Our ref: Murwillumbah Education Campus (SSD-16848913)

Subject: Request for Additional Information

I refer to Assessment for the Murwillumbah Education Campus (SSD-16848913). The Department of Planning and Environment (the Department) has identified a need for additional information to support the ongoing assessment of the application.

Figure 3.7: Kiss'n'drop Facility

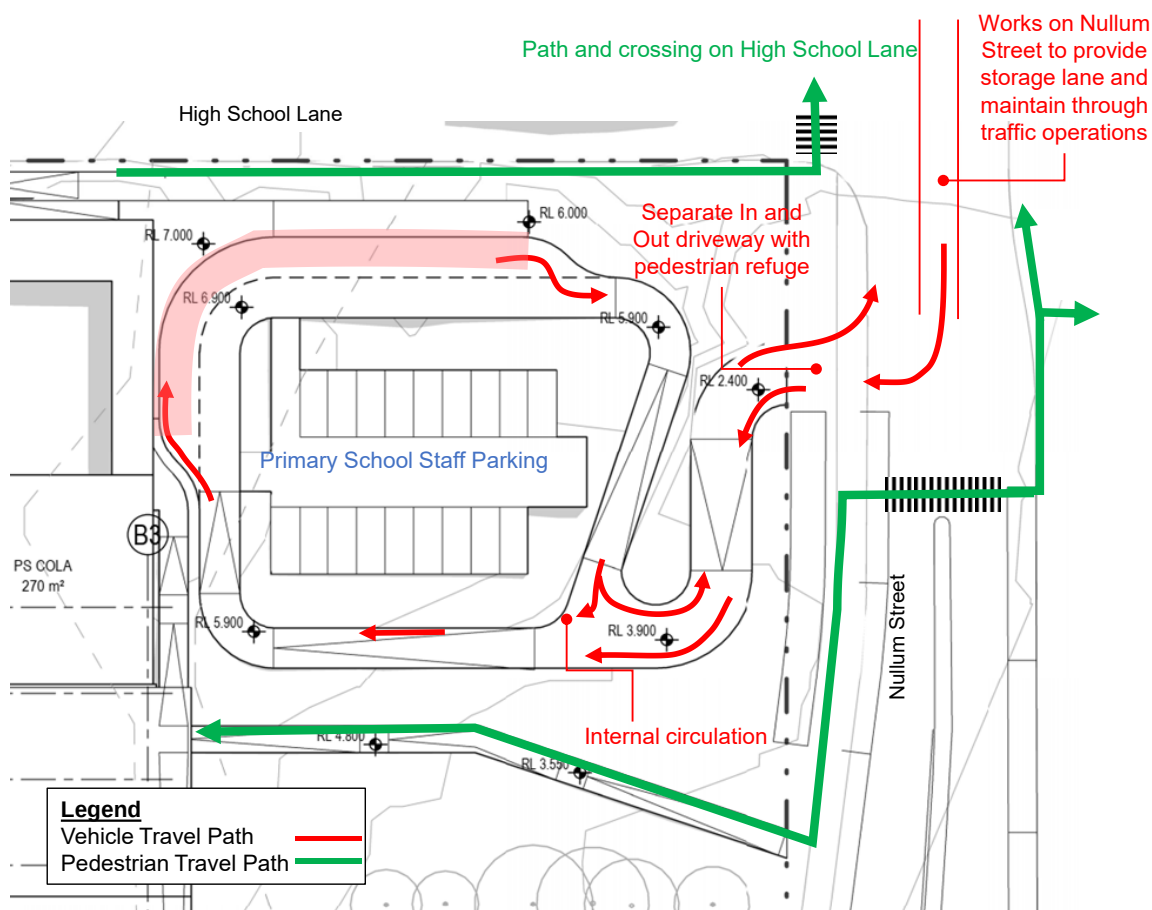
- the location of the six proposed drop-off/pick-up bays proposed by amending relevant plans to include line marking and notation
- measures to manage queueing impacts within the drop-off/pick-up area
- expected queue lengths within the drop-off/pick-up area based on any measures that would be implemented as required above
- confirmation that the measure(s) are suitable to contain queue lengths within the site and would not impact bus movements on Nullum Street.
